Martin Nugent  
01254 828060  
D3/11/0533

Drafted 27 September 2011

**Planning Application, Ribble Valley District  
D3-11-0533 land at 5 Hazeldene, West Bradford**

4123 - 03c

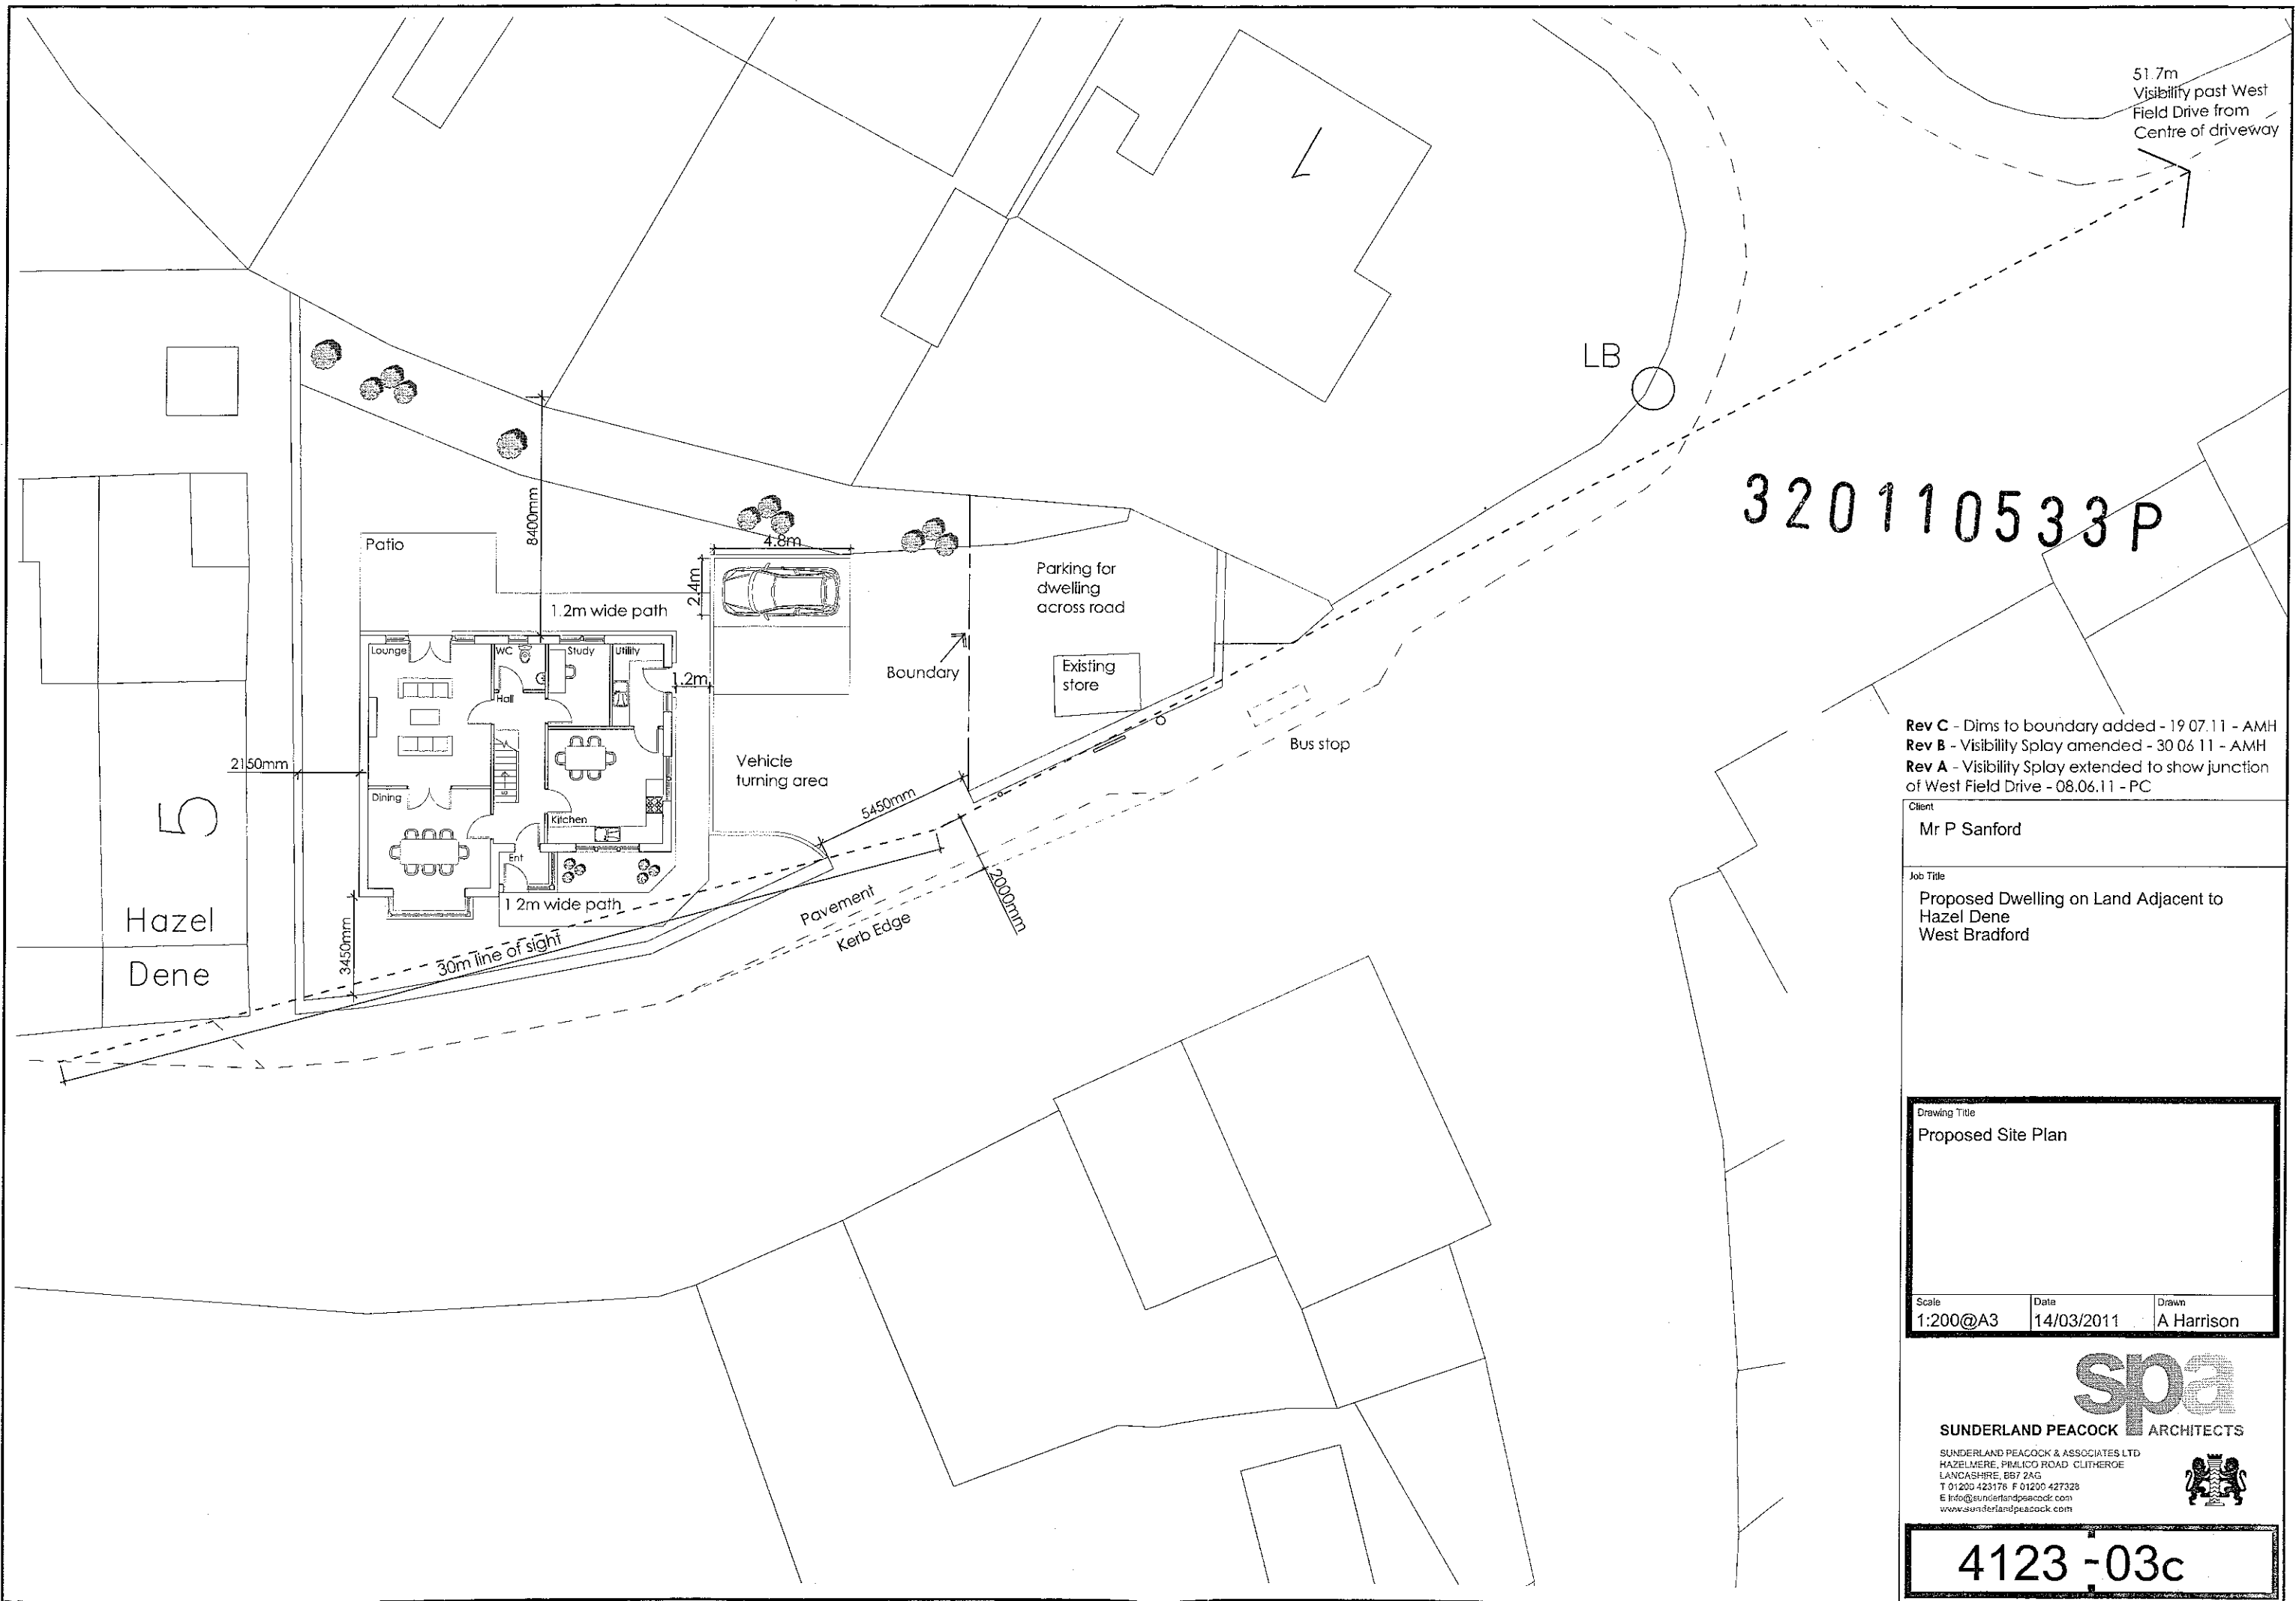
The Applicant has indicated that there are two off road car parking spaces within the site. This is consistent with the proposed three bedroom residential property.

The site lines from the proposed access have been measured from 2.0m back from the edge of carriageway. This is a permitted variation on the standard 2.4m measurement, consistent with this low speed residential location. The sightlines identified of 2.0m by 30m to the west and 2.0m by 51m to the east are satisfactory at this location, in line with the parameters set out in Manual for Streets 2.
